East Anglia ONE North and East Anglia TWO Offshore Windfarms

Applicants' Responses to Examining Authority's Written Questions

Volume 10 - 1.8 Historic Environment

Document Reference: ExA.WQ-1.D1.V1_10

Figure: 29.21b  
Viewpoint 9: B1121 Aldeburgh Road, south of Friston

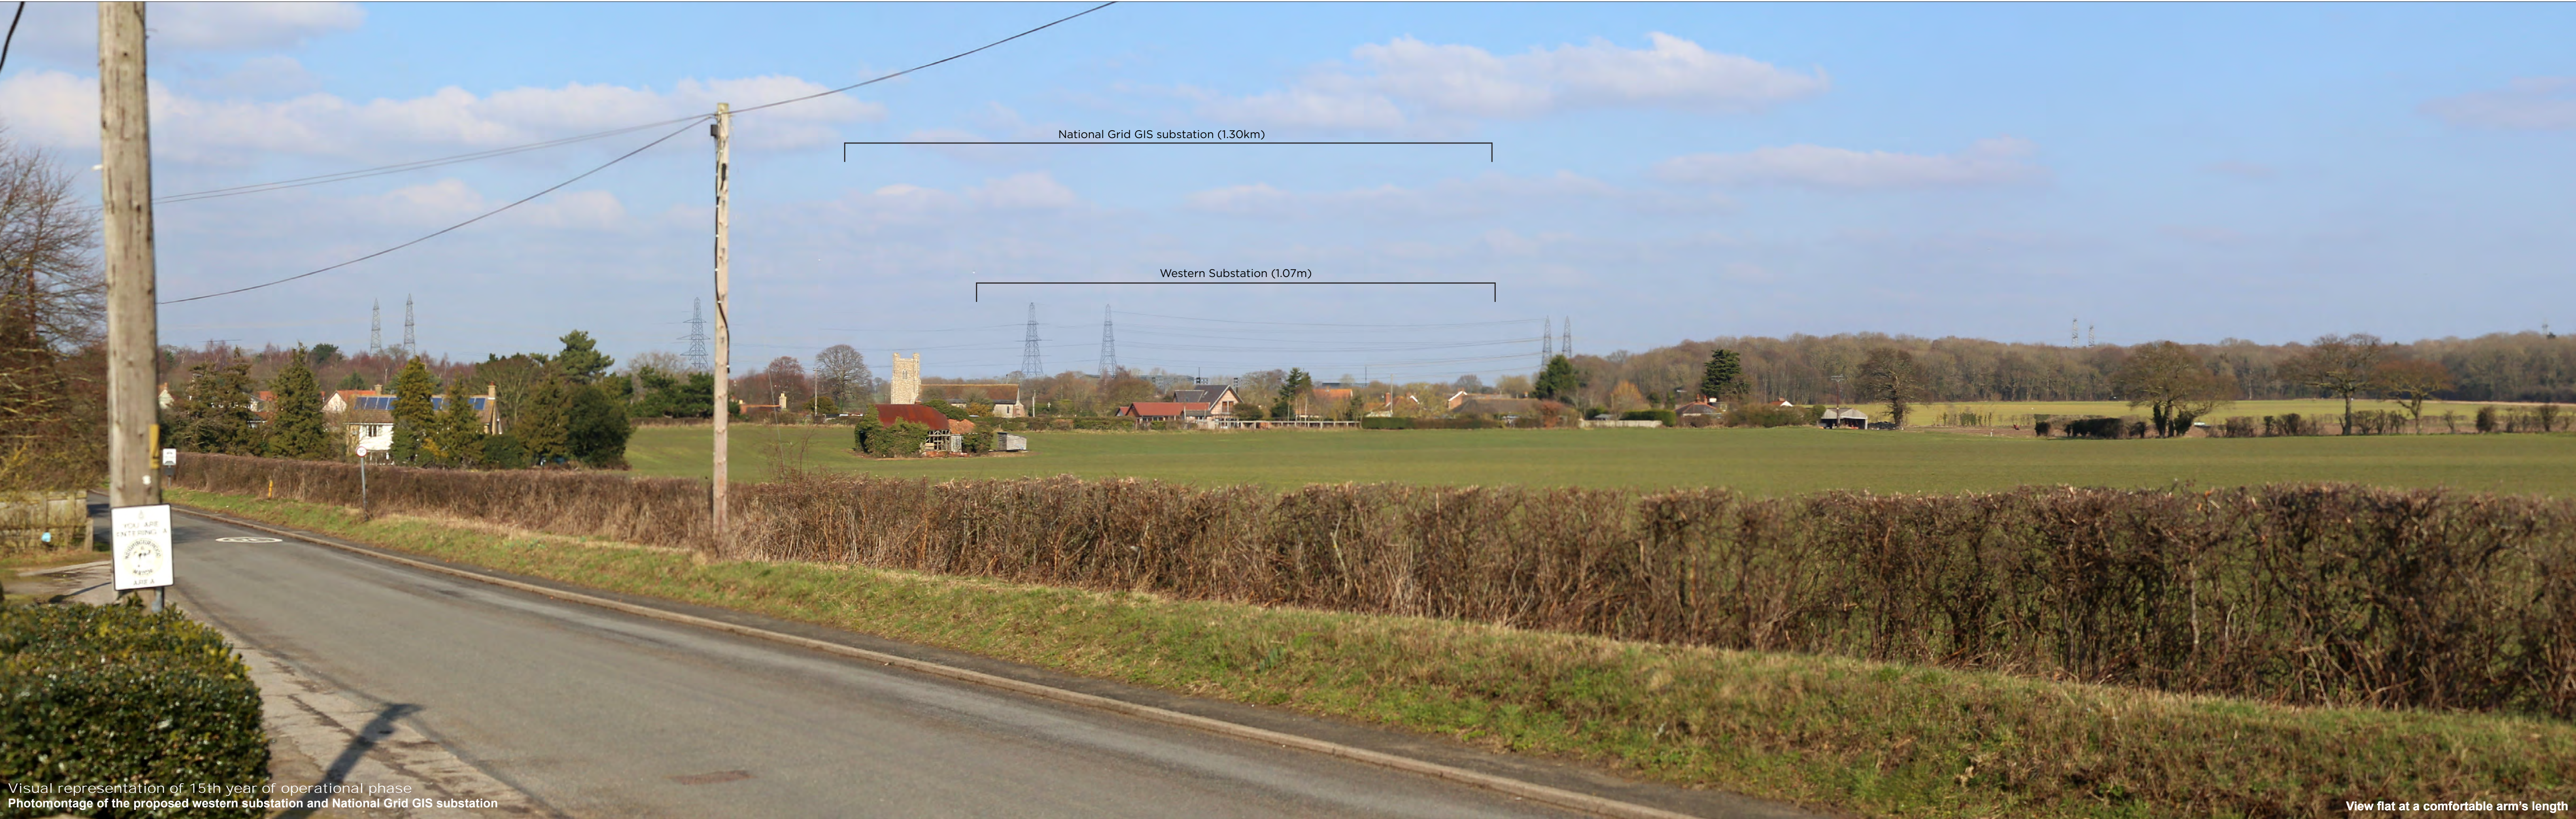
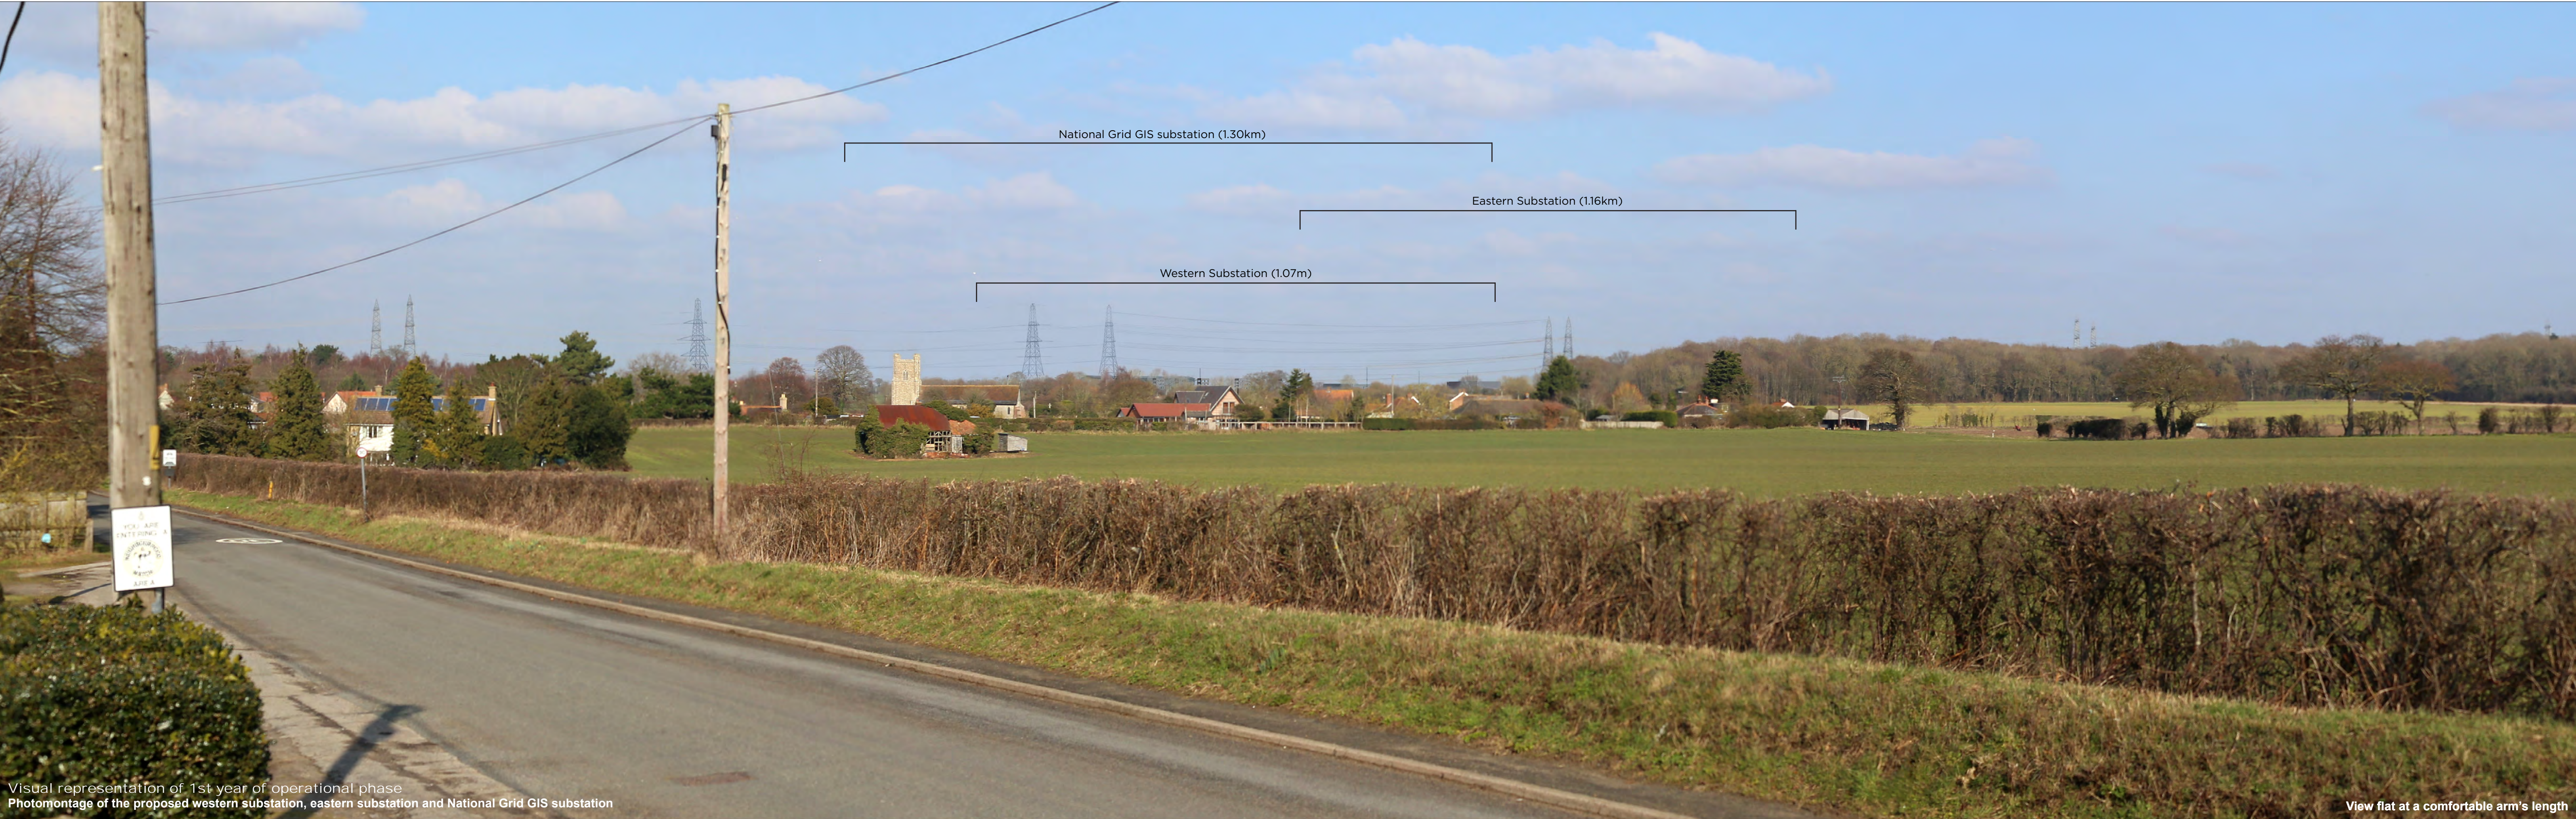
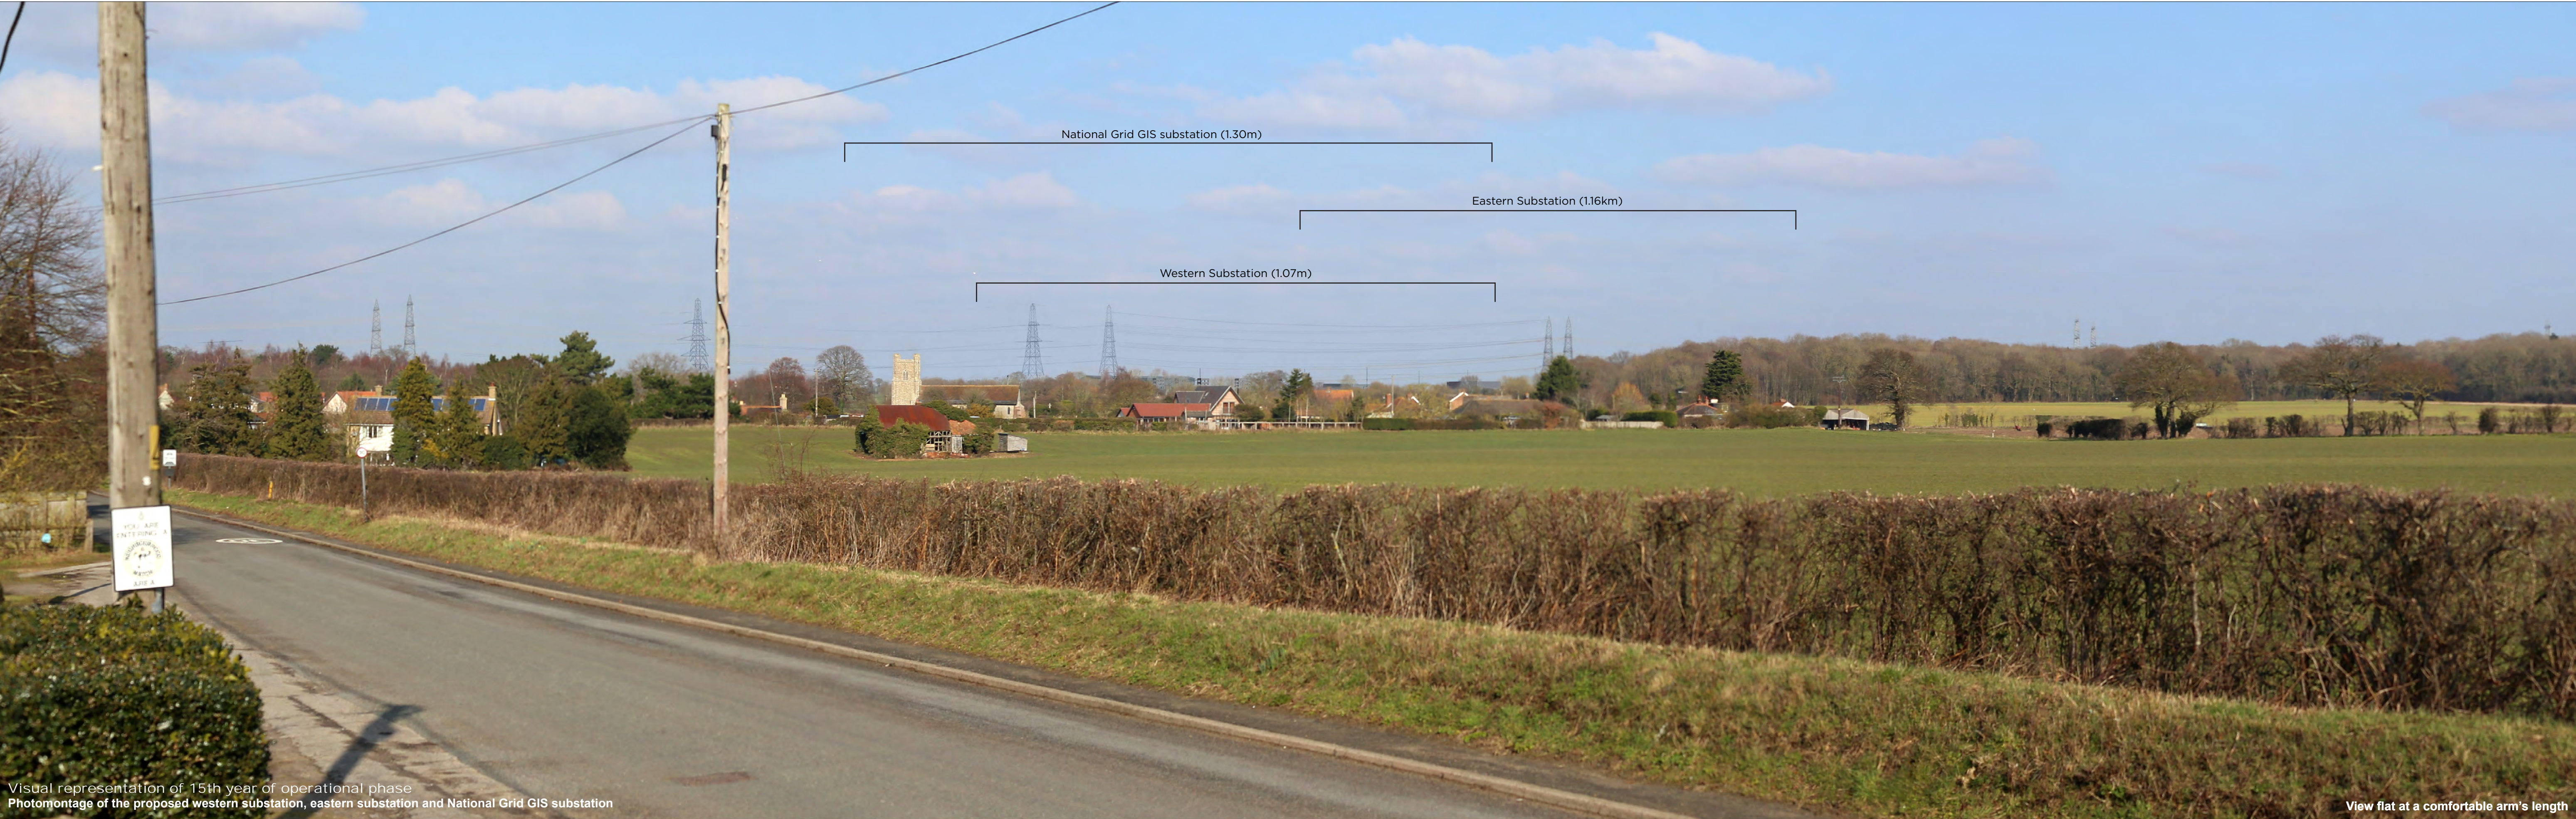
1.8.8	The Applicant	1	2	<p>Church of St Mary - Friston Your representation [RR-47] states that you consider that the scale and appearance of the proposed developments would significantly change the character of the rural landscape setting of the Church, greatly impacting on key views of the church from the south, which would be seen against a backdrop of the sub-stations. The ExA note the responses of the Applicant to this point of view in their responses to the RR [AS-036] and note your view that the proposed works would remain subordinate to the Church.</p> <p>a) Provide further justification in support of your view that the contribution made by setting to the significance of the church in these views would not be materially affected. How would any harm from such views add to or contribute to harm caused by changes to the northern views of the Church?</p> <p>Quoting from RR-47, Historic England states that: <i>"It would also greatly impact on key views of the church from the south, which would be seen against a backdrop of the sub-stations."</i></p> <p>In the Applicants' assessment it is recognised that the proposed location of the substations to the north of the church created a potential for church and substations to be seen together in views from the south. Given that the Applicants had identified the visual prominence of the church as a component of its significance, it was possible that visual competition from the substation could adversely impact on this component of significance.</p> <p>Fieldwork led to the identification of various locations broadly to the south of the church where there were informative views of the church. Photomontages were prepared to illustrate the predicted visual change at representative viewpoints within each of these areas. These included relatively short-range views within the village (CH VP1 and LVIA VP6 of Appendix 24.7 (APP-519 &</p>

ExA. Question Ref.	Question addressed to	ExA. Question		Applicants' Response
				<p>APP-520)), approaching the village from the south on the Aldeburgh road (LVIA VP9) and approaching the village on a PRow from the south-west (CH VP2). In all four cases, if the photomontages are taken to their respective viewpoint locations, it is clear that whilst the highest structures within the substations might be visible, this is not sufficient to distract attention. The visual prominence of the church is preserved and the contribution made by this aspect of setting to the significance of the church is unaffected.</p> <p>Historic England does not define which views it considers to be “key views of the church from the south” but at no time has it drawn the Applicants' attention to viewpoints in addition to those that are illustrated in the ES. The Applicants maintain that the low level of visual change shown in the photomontages does not support the Historic England conclusion that the substations would ‘greatly impact’ on these views.</p>
